Our Ref: PE/ARU/13/10/B

Date: 17th September 2013

Re: Hollyacre Toddington Lane, Littlehampton, West Sussex.

Drawing Title
Plot 61
Plans and Elevations

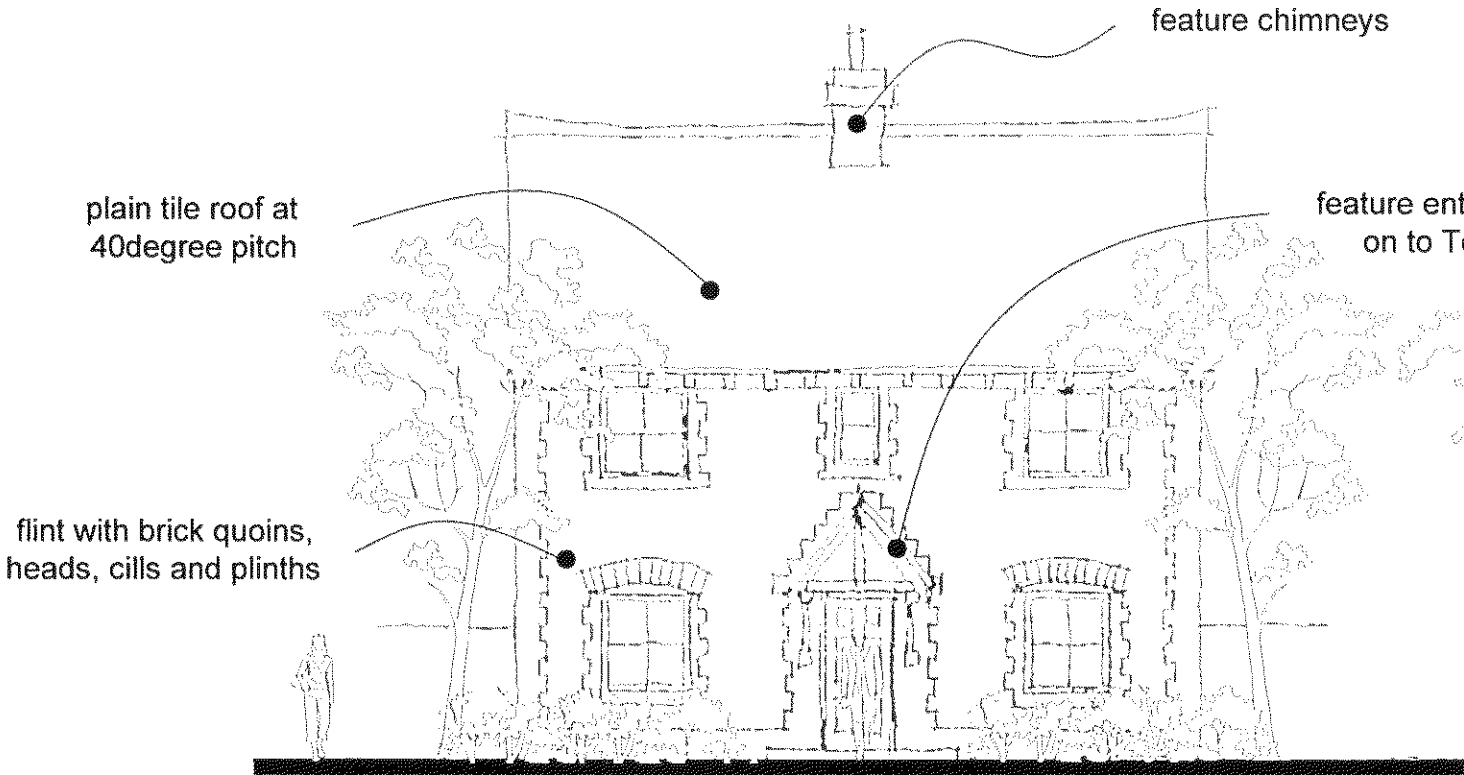
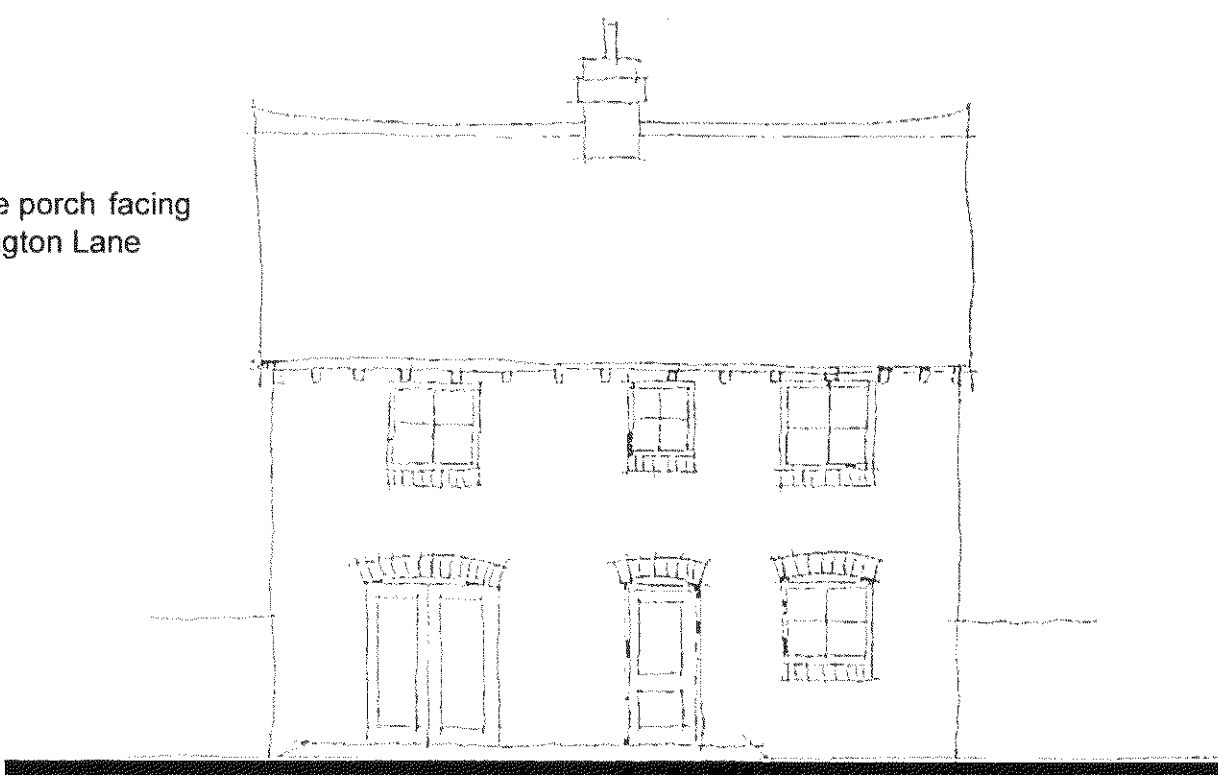
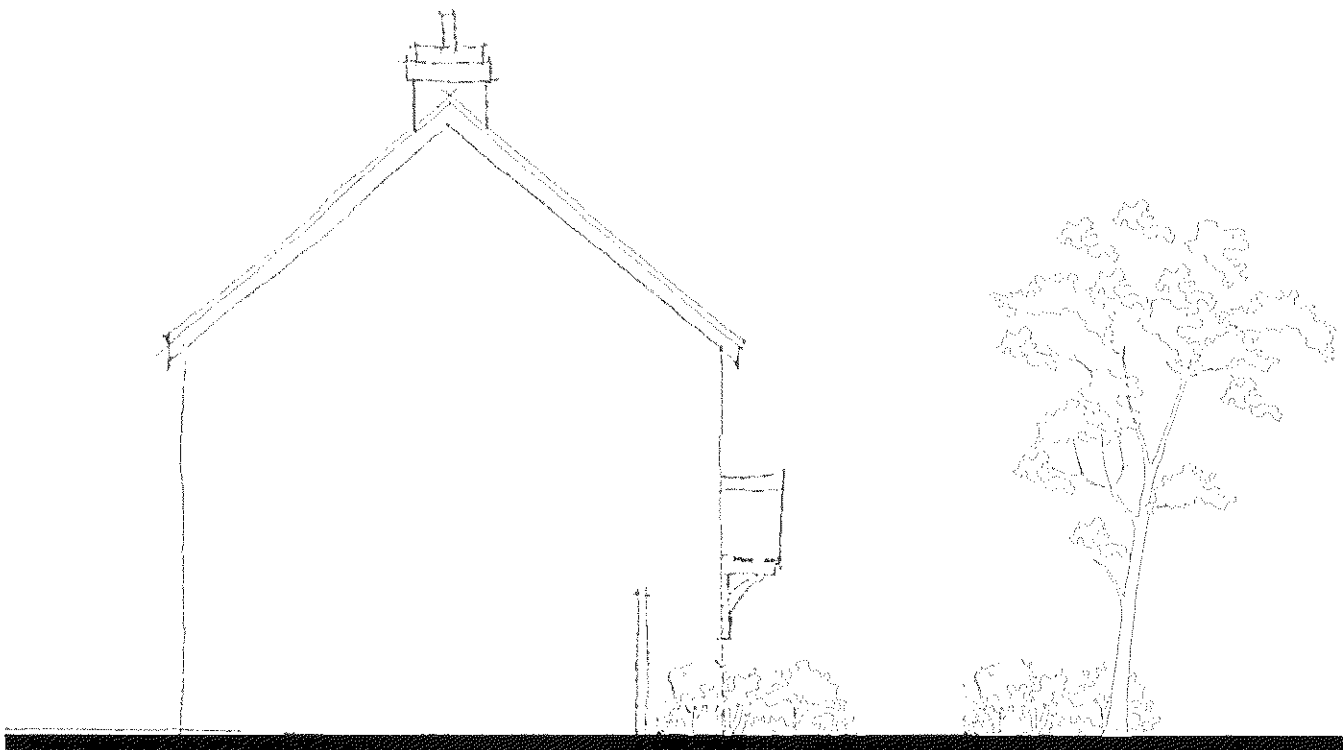
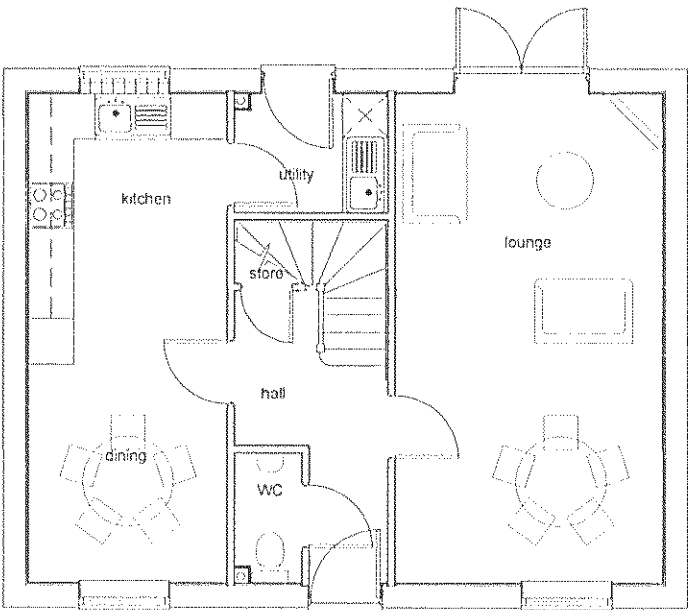
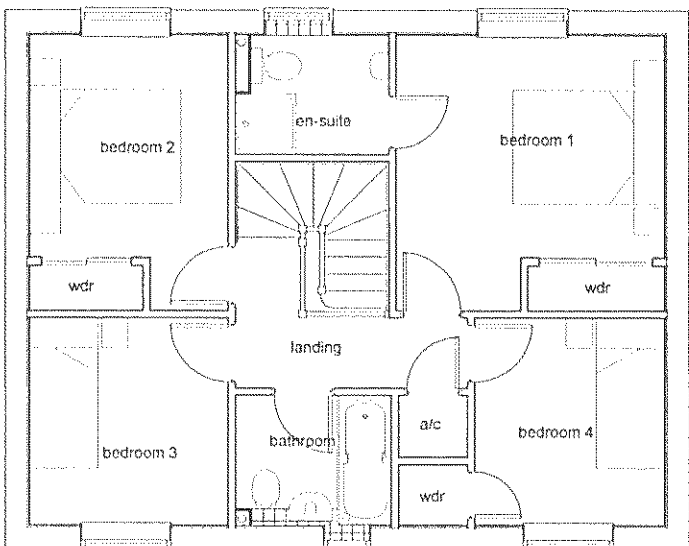
The amendment addresses the spaces between dwellings. However, my previous concerns of PE/ARU/13/10/A with the numerous access points into the development, including those between plots 61 & 60 and plots 20 - 21 have not been addressed. These access points lead directly to an unobserved rear car parking court behind 60 - 61 and the access point between 20 -21 leads to a poorly overlooked parking court; i.e. there are only two active rooms from the flat over garages that overlook the rear of 14 dwellings here.
